An
Bord
Pleanála

Inspector's Report ABP-320327-24

Whether or not: (a) Structure No. 1: Gate Lodge A and Gate Lodge B; (b) Structure No. 2: semi-detached agricultural storage facility; (c) Structure No. 3: detached agricultural maintenance/storage facility; (d) Structure No. 4: electricity distribution building; (e) Structure No. 5: open fronted agricultural storage shed; (f) Structure No. 6: former agricultural building, now used to accommodate protected persons; (g) Structure No. 7 and Structure No. 8: pavillion and kitchen building; (h) Structure No. 10: former Belfry Building; (i) Structure No. 11: concrete paved area adjacent to structure no. 10 and 12; (j) Structure No. 12: accommodation block no. 1; (k) Structure No. 13: Art O'Neills building; (l) Structure No. 14: car park adjacent to the former Belfry Building; (m) Structure No. 15: large gravelled area to the north east of the holiday village; (n) Structure No. 16: accommodation block no. 2 and (o)

Kippure Lodge and Holiday Village,
Kippure Estate, Manor Kilbride,
Blessington, County Wicklow.

Structure 02

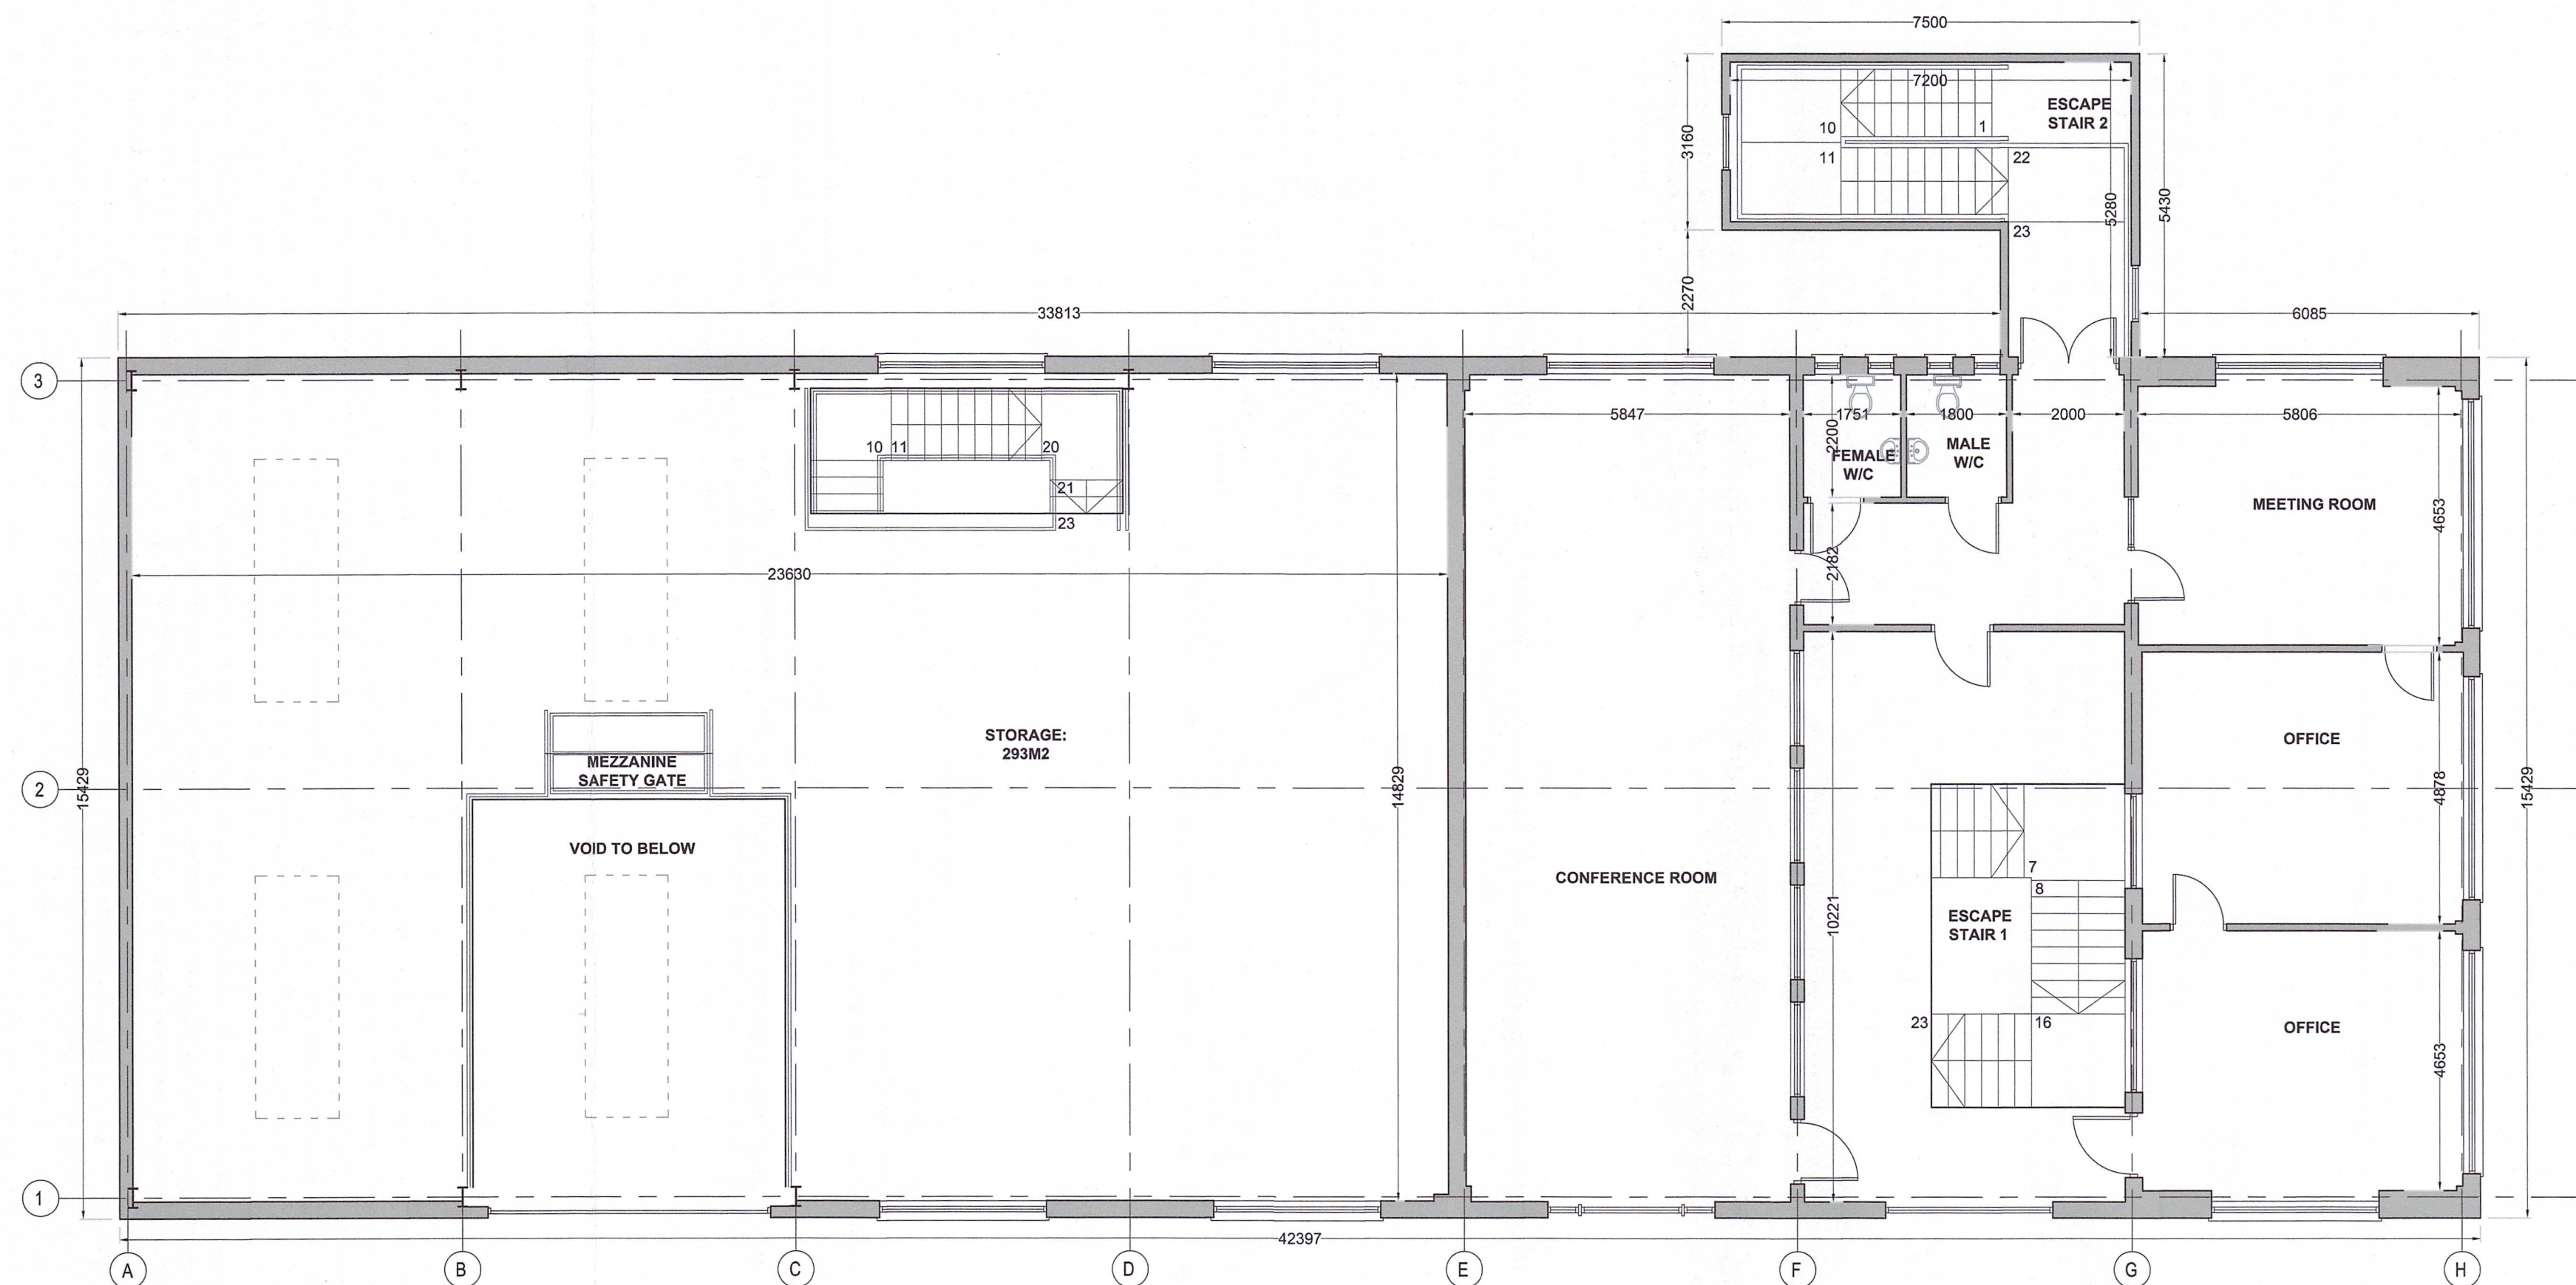
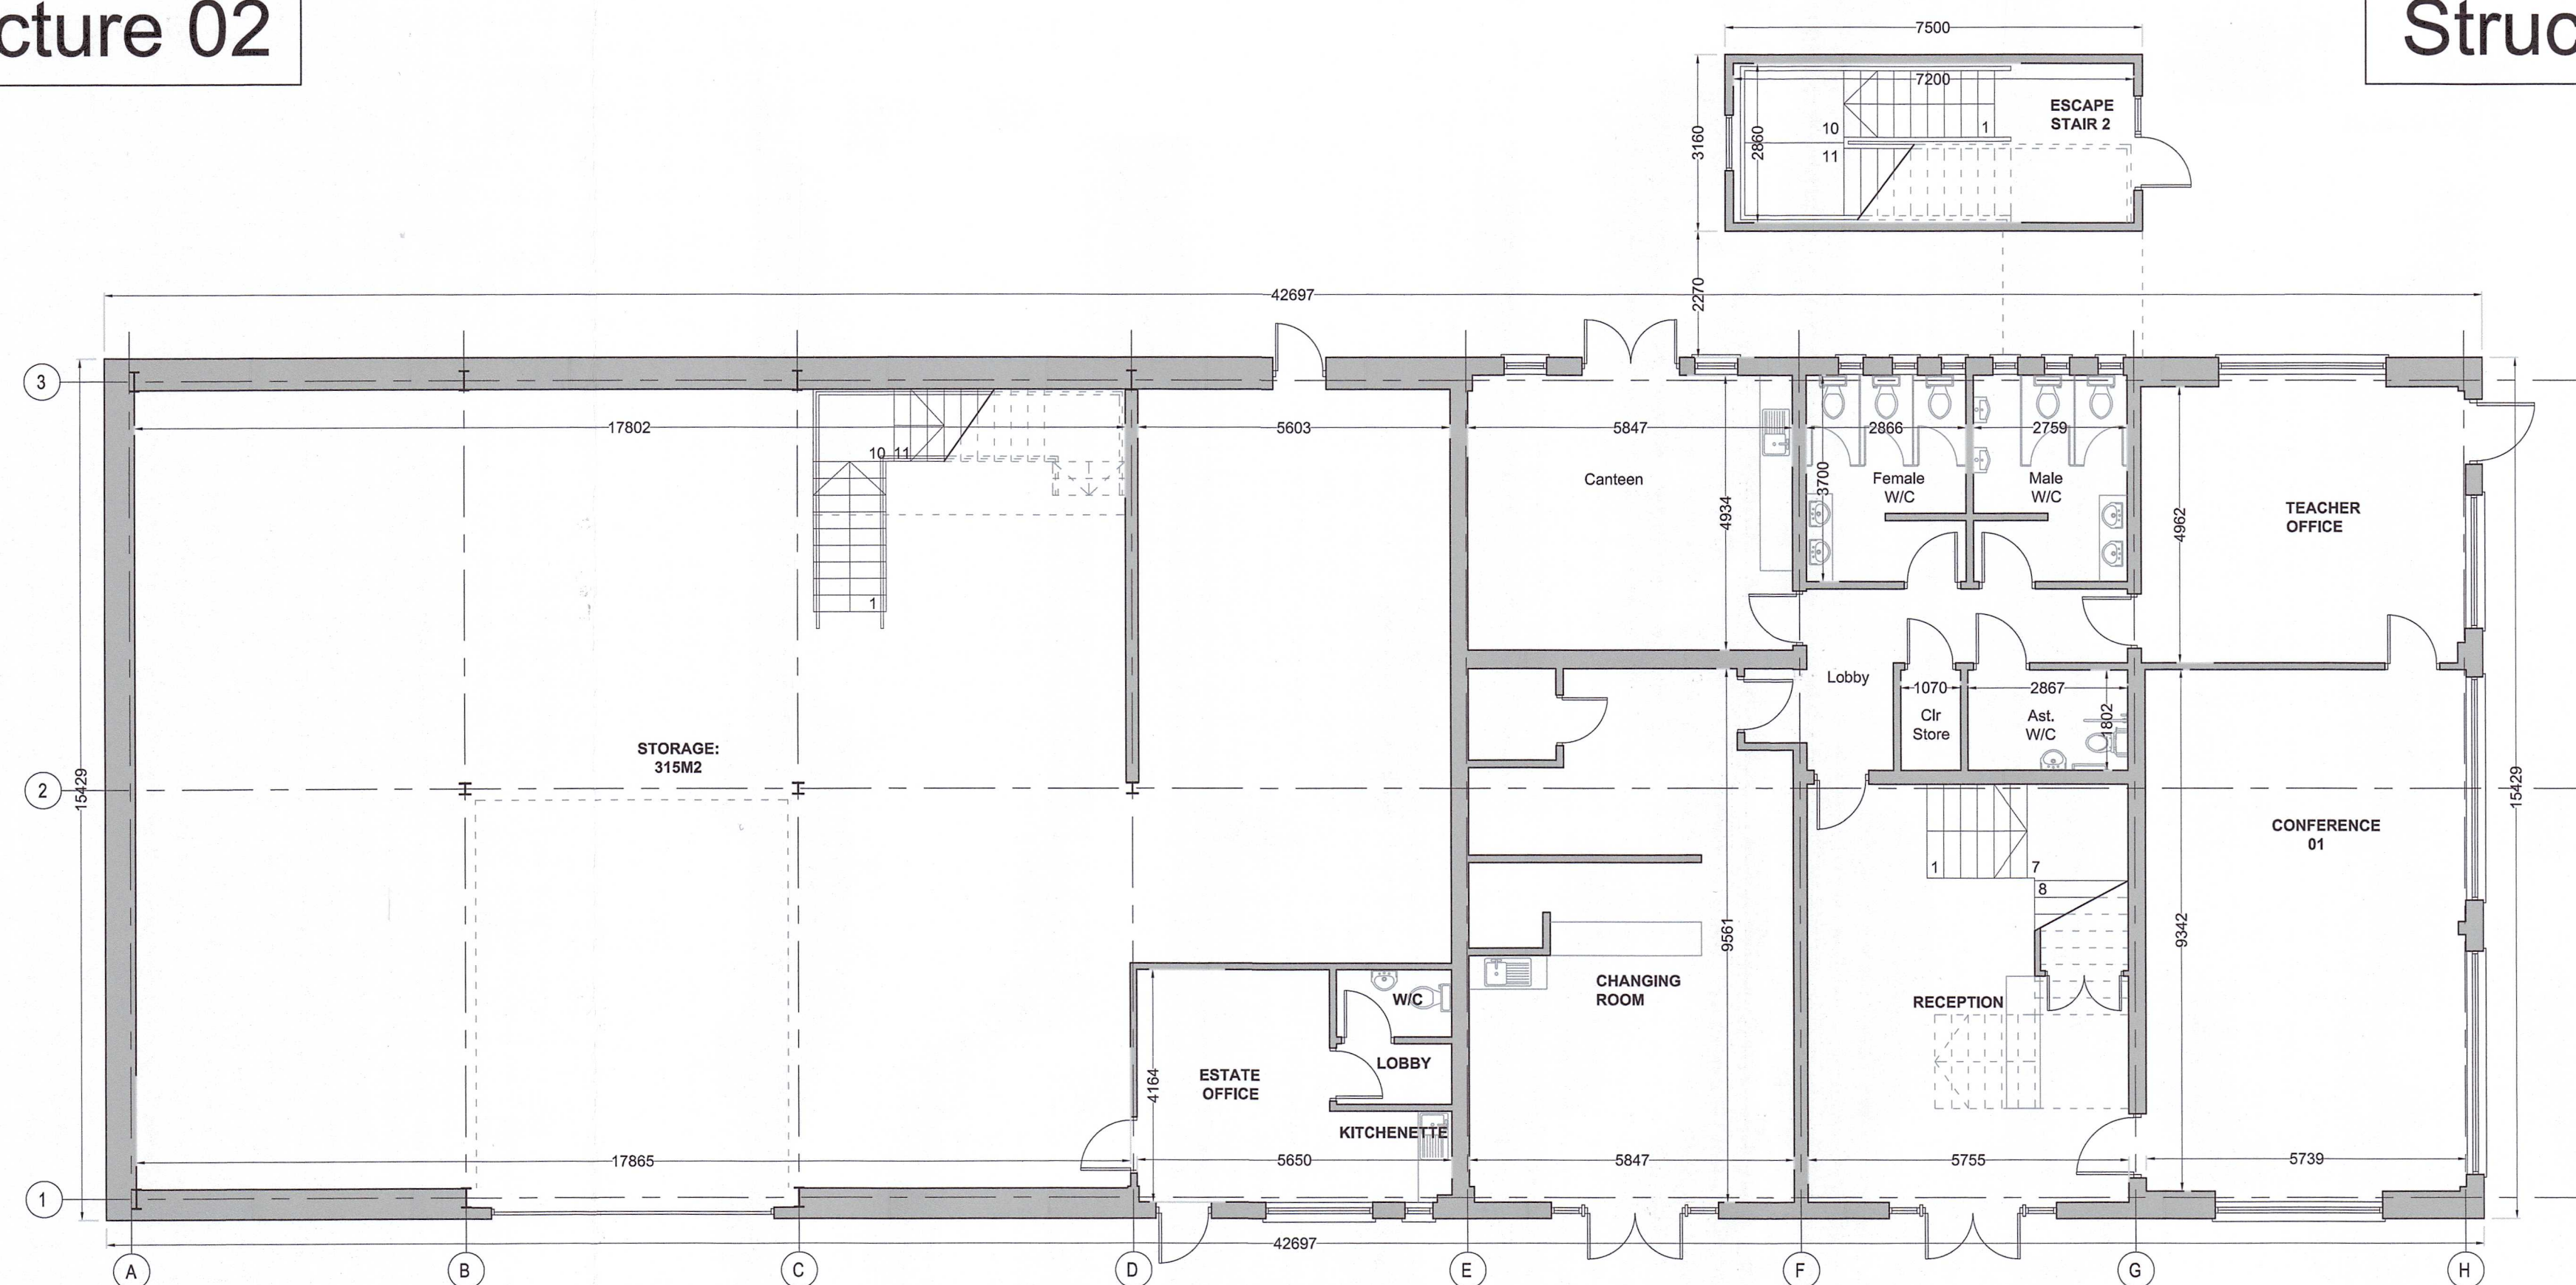
It would appear from aerial photography that this structure and the adjacent structure no. 6 were constructed between January 2020 and March 2022. The structure come within the meaning of works and would therefore come within the meaning of development as provided for in Section 3(1) of the PDA. Class 9 of Part 3 -Exempted Development - Rural of Schedule 2 provides an exemption for any store, barn, shed, glass house or other structure, having a gross floor area (GFA) not exceeding 300sqm. The structure has a GFA of 660sqm.

- From an inspection the structure is in use for the storage of building materials and would not appear to be in use for agriculture, as defined under Section 2 of the PDA.
- Taking into account the overall floor area of this structure and Structure no. 6 (1,134sqm) it would exceed the aggregate 900sqm limitation.
- The structure is in excess of 10m from the public road.
- The structure is not within 100m of any house.
- Metal sheeting on the structure is painted.

The structure would not come within the provisions of Class 9 and therefore is not exempted development.

Class 9 of Part 3 of Schedule 2 provides an exemption for any store, barn, shed, glass house or other structure, having a gross floor area (GFA) not exceeding 300sqm. The structure has a GFA of 500sqm (excluding the external stairwell).

- This structure is indicated to have been in agricultural use however no evidence is provided.

- Taking into account the overall floor area of this structure and Structure no. 2 (1,134sqm) it would exceed the aggregate 900sqm limitation.
- The structure is in excess of 10m from the public road.
- The structure is not within 100m of any house.
- Metal sheeting on the structure is painted.

Structure 03

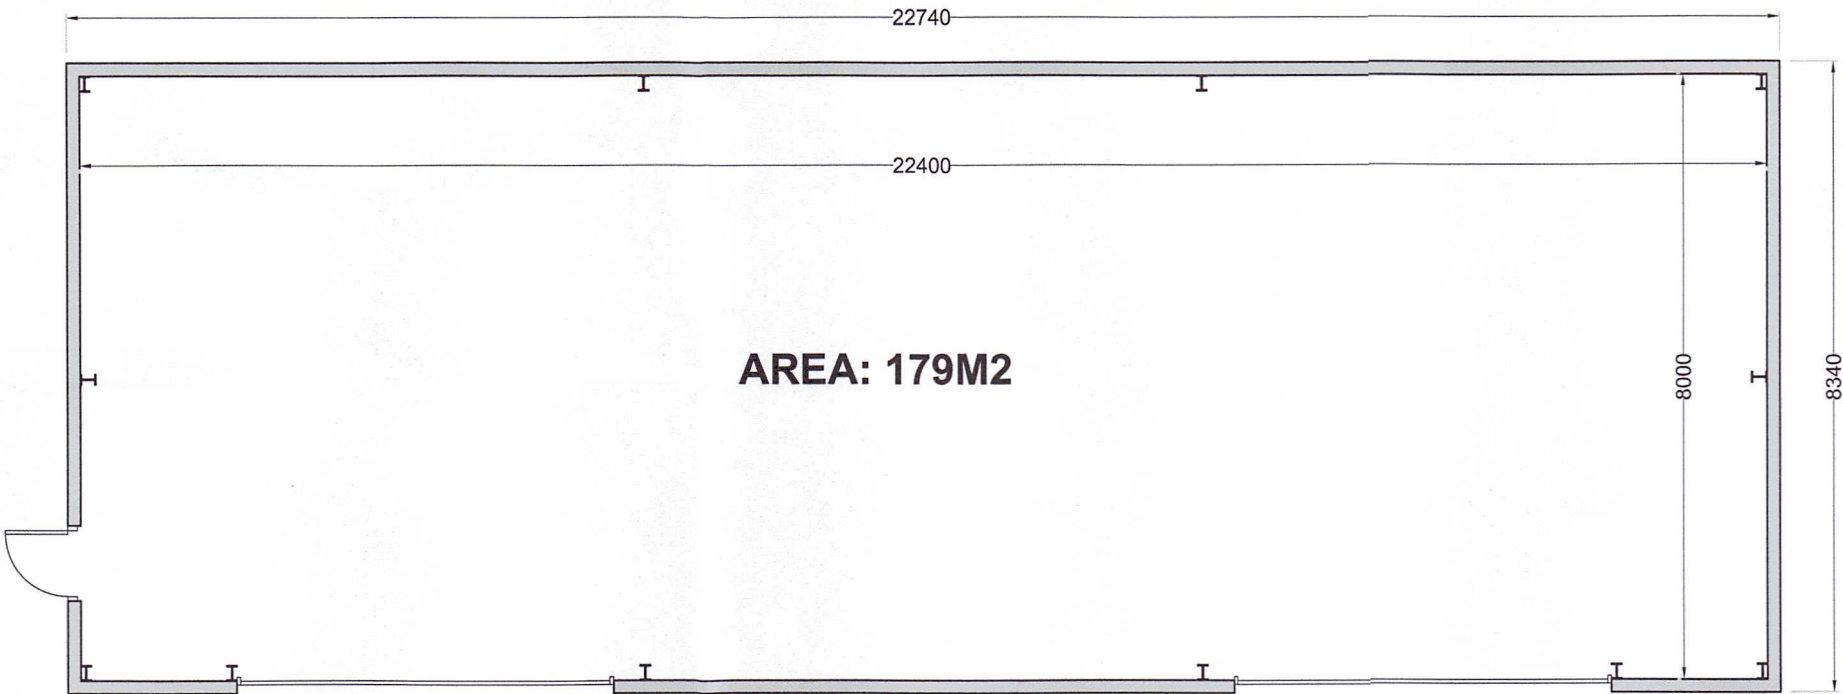
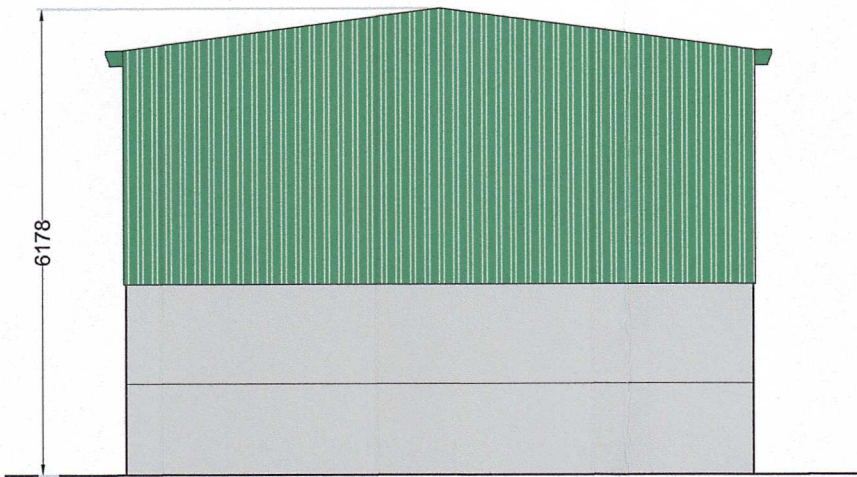
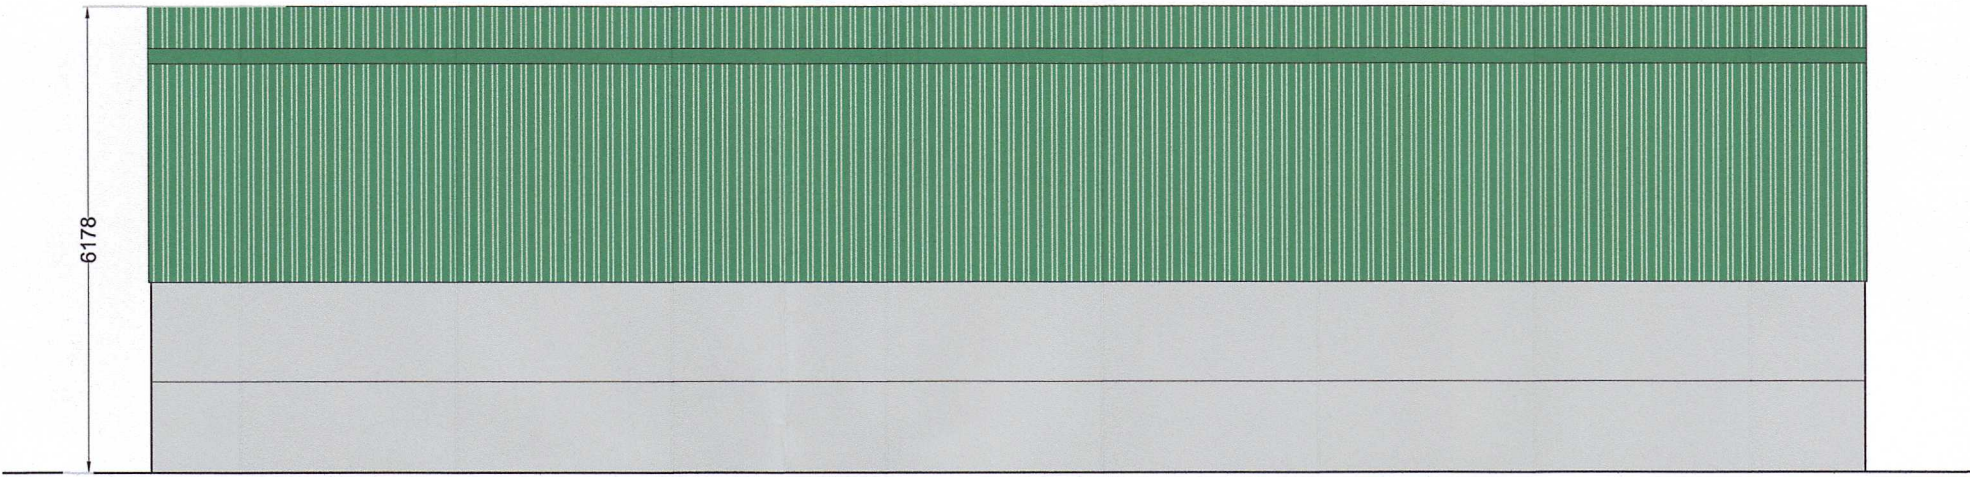
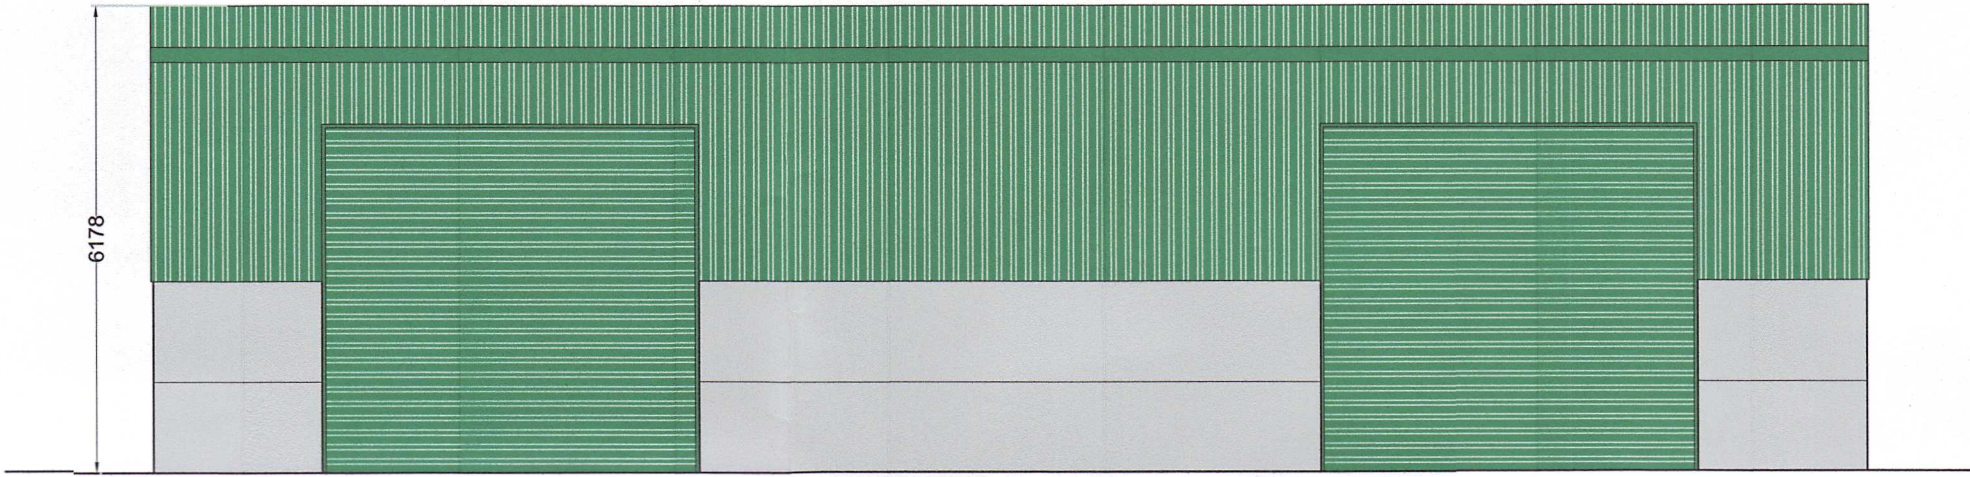
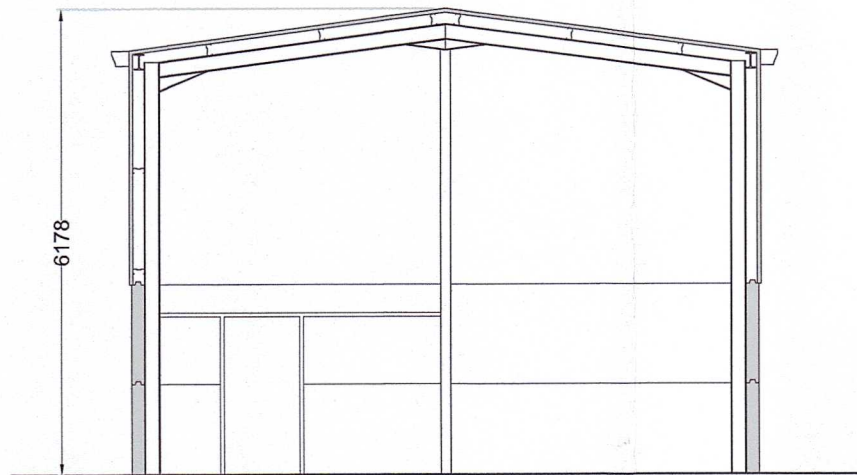
Class 9 of Part 3 of Schedule 2 provides an exemption for any store, barn, shed, glass house or other structure, having a gross floor area (GFA) not exceeding 300sqm. The structure has a GFA of 179sqm.

- No evidence is provided to confirm the structures use and there appears to be some storage in relation to the construction works on site.
- Structure no. 2 and 6 were completed prior to this structure and have an overall area of 1,134 sqm and would exceed the aggregate 900sqm limitation.
- The structure is in excess of 10m from the public road.
- The structure is not within 100m of any house.
- Metal sheeting on the structure is painted.

The structure would not come within the provisions of Class 9 and therefore is not exempted development.
